ITEM 6.1

**85 Harrington Street
The Rocks
GOLDEN AGE & HANNAS THE ROCKS**

TITLE
**RESPONSE TO DoPE
ITEM 6.1**

TITLE
 Diagrams
 SCRA Envelope Comparison

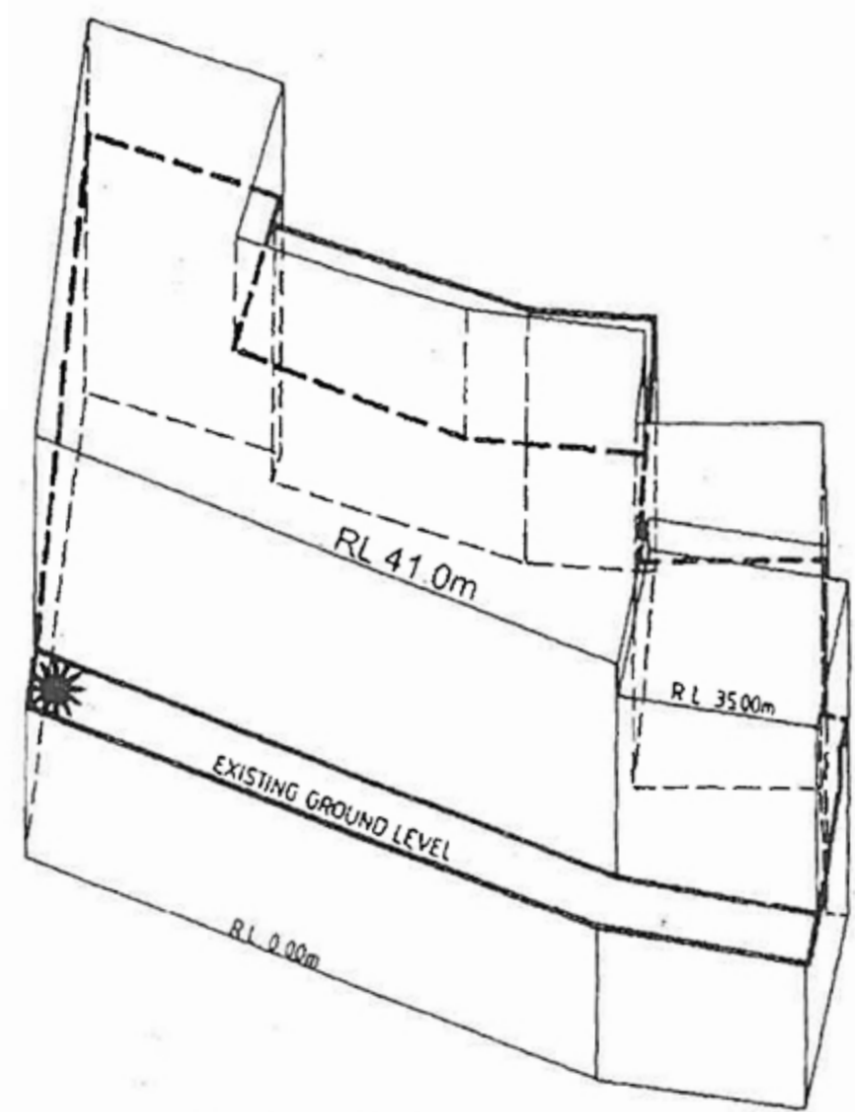
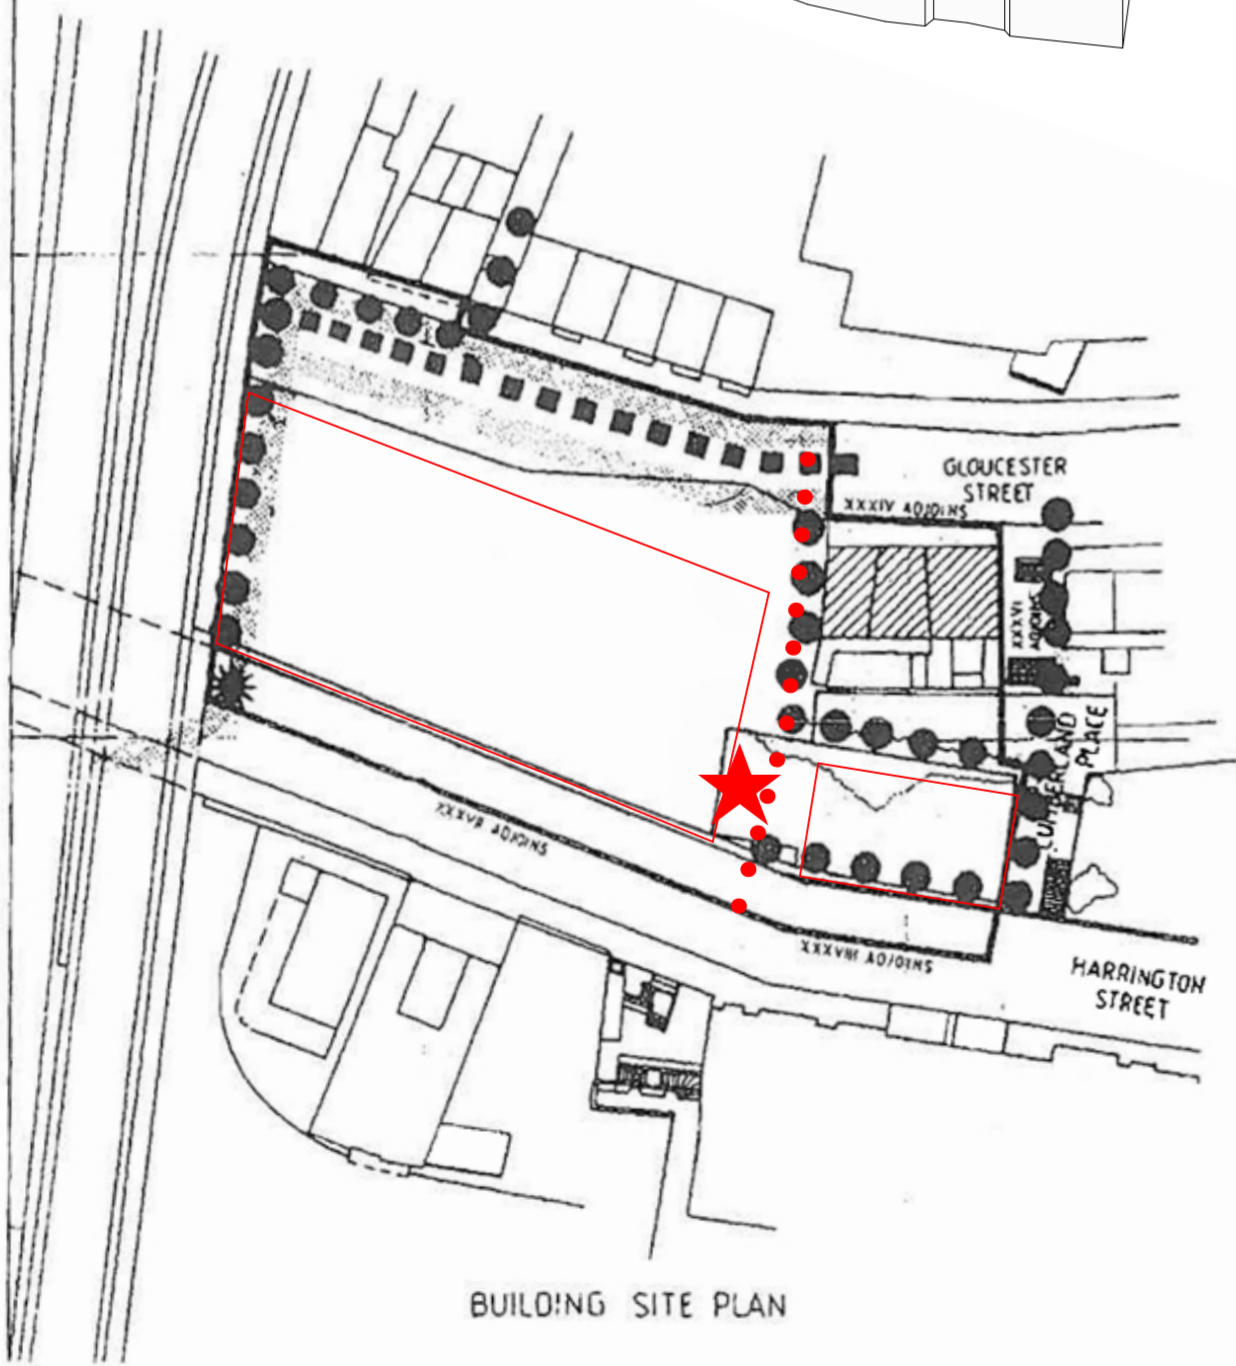
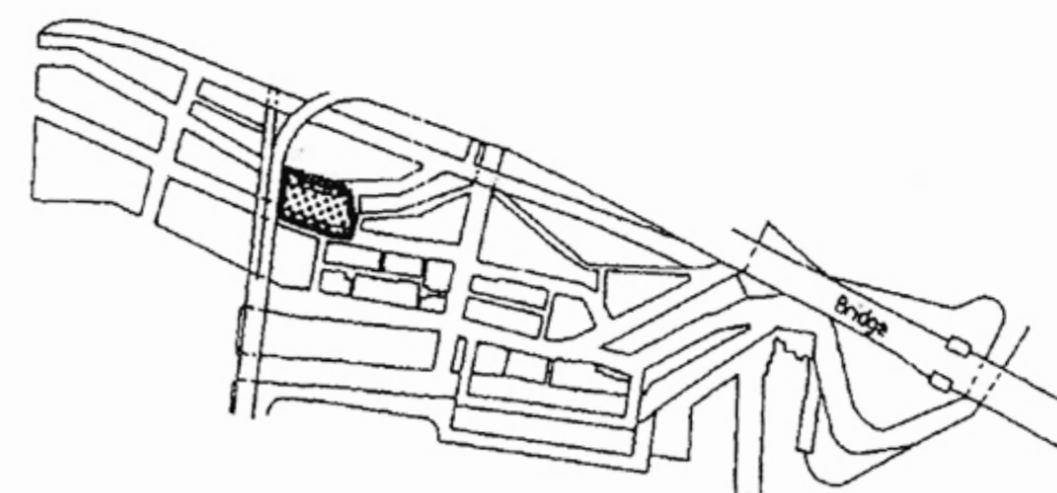
Issue/ Objection:
Bulk and Scale

Description:
Concerns regarding increase in height and scale that is exceeding SCRA envelope.

Response
Height and bulk supported by Peter Webber.
As such no action is taken with regards to height and bulk objections.
